**Consultation Response from KC,
Lead Local Flood Authority**

2026/90946 J L Brierley, Turnbridge Mills, Quay Street, Huddersfield, HD1 6QT

Date Responded: 13/04/2026.

Discharge of Drainage Conditions

Title: Drainage Details Sheet 2 of 2

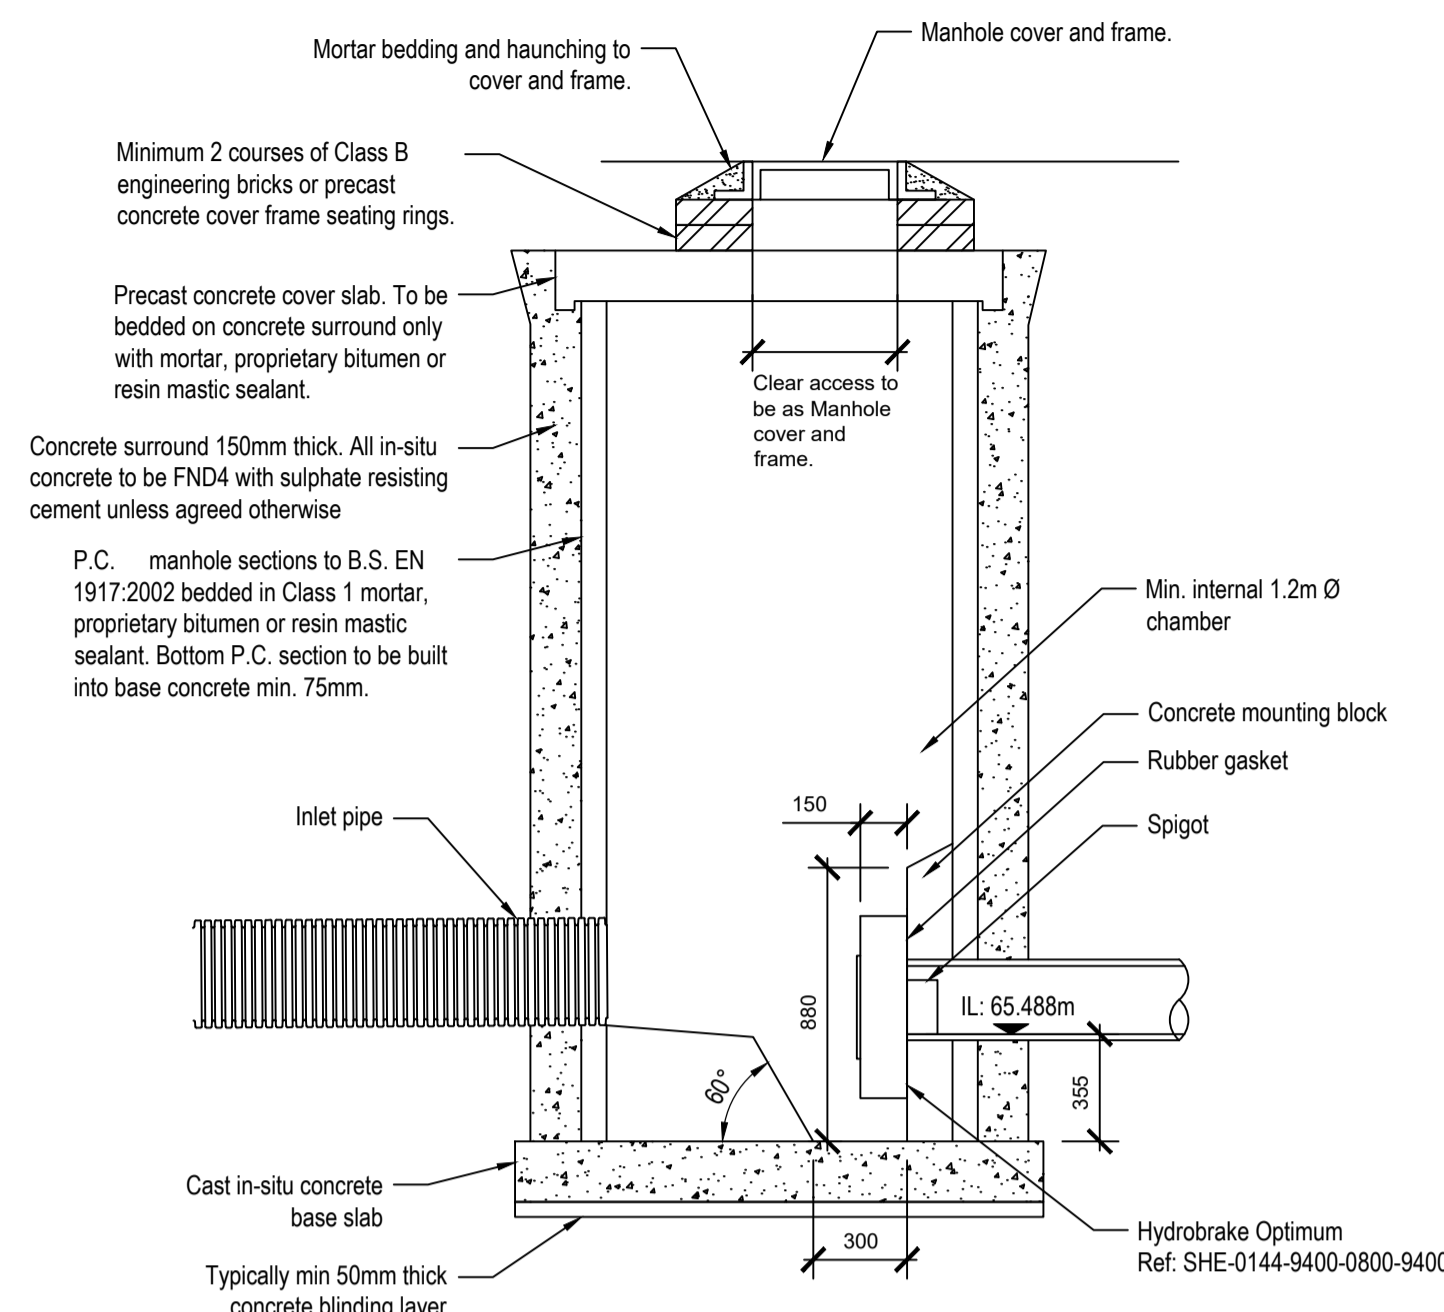
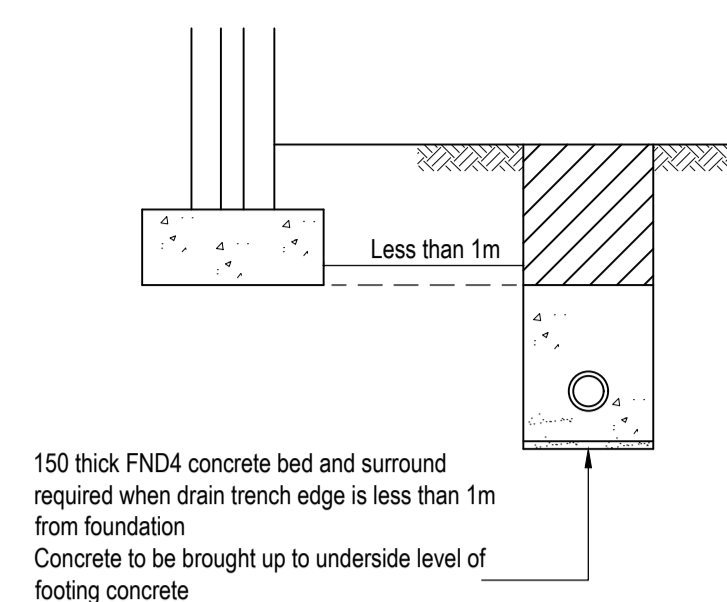
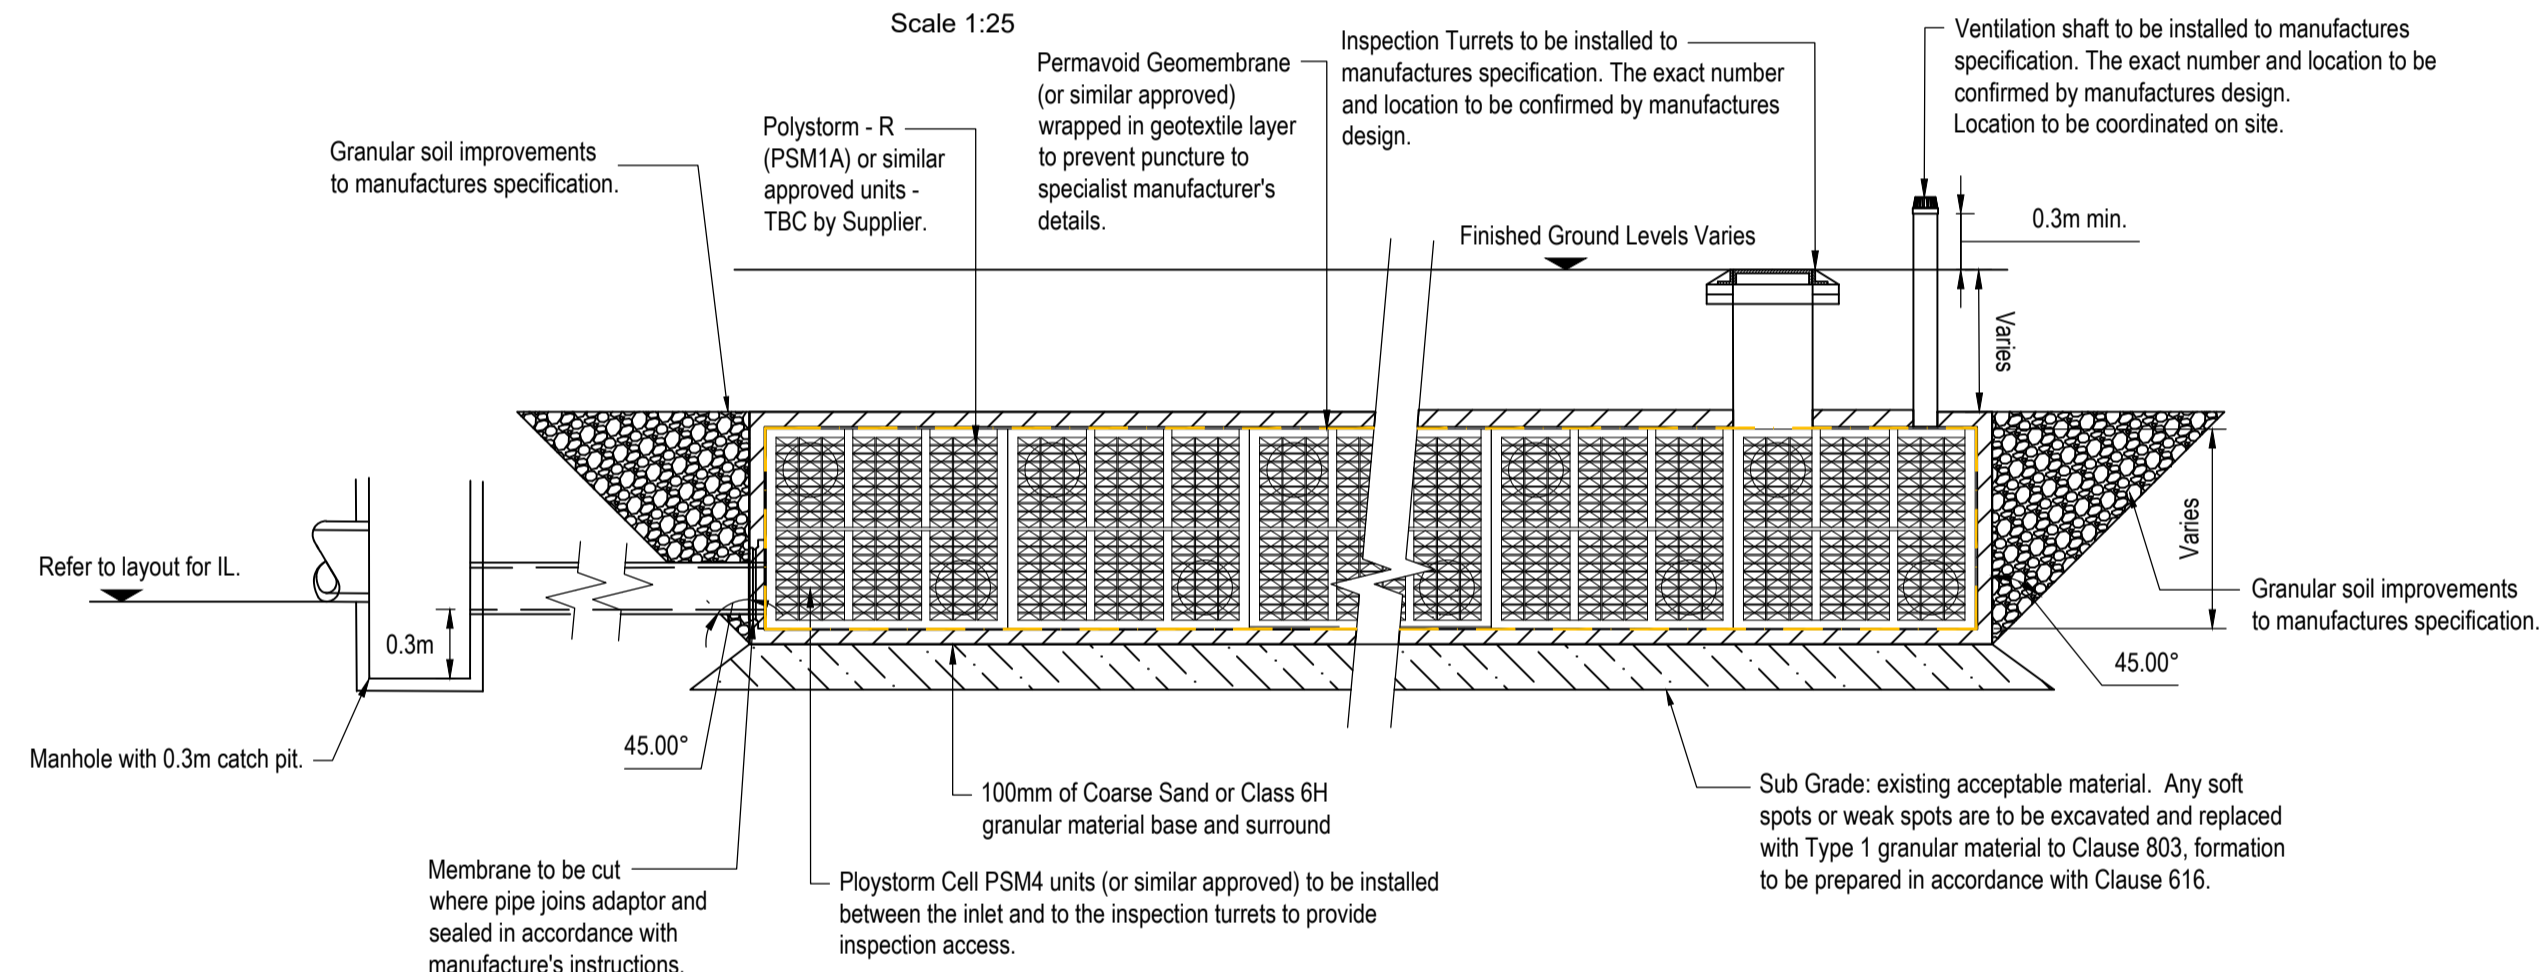
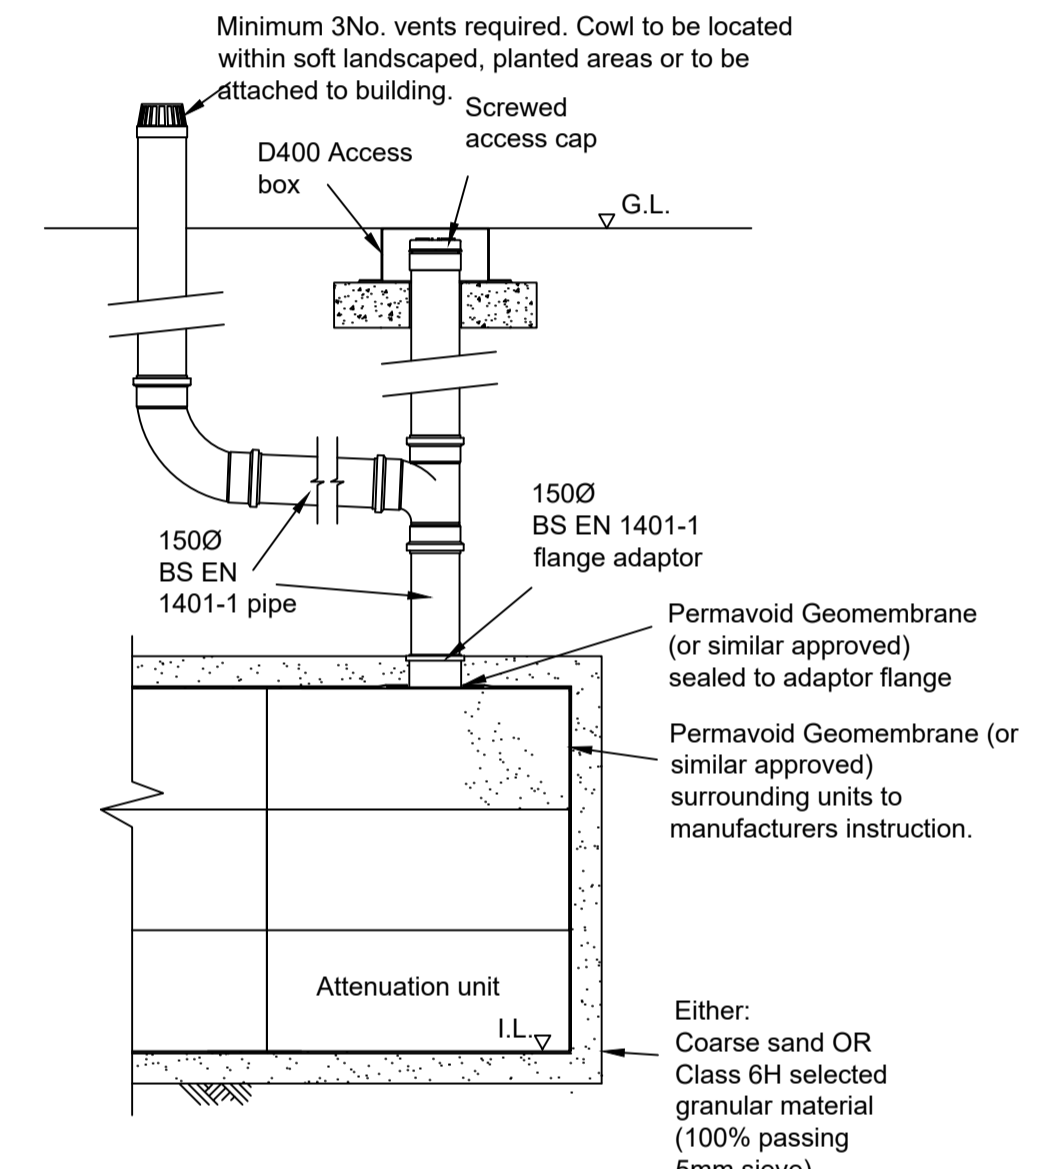
The LLFA confirms that the details of the proposed drainage layout, drainage details and the oil separator proposal are acceptable including the proposed surface water discharge rates to the Yorkshire Water Sewer in Old Leeds Rd (subject to YW approvals) and the Huddersfield Broad Canal (subject to Canal Trust approvals). However, the Decision Notice for application 2025/91122 also required the following information to be submitted for Condition 23:

- Hydraulic calculations;
- Phasing of drainage provision;
- A risk assessment and method statement, in accordance with CDM Regulations 2015, for access to and into the attenuation structure; and
- A maintenance and management plan for surface water infrastructure

The developer is required to submit the above documentation to allow the LLFA to fully discharge the condition.

Therefore Condition 23 **cannot be** discharged until this information is submitted for approval.
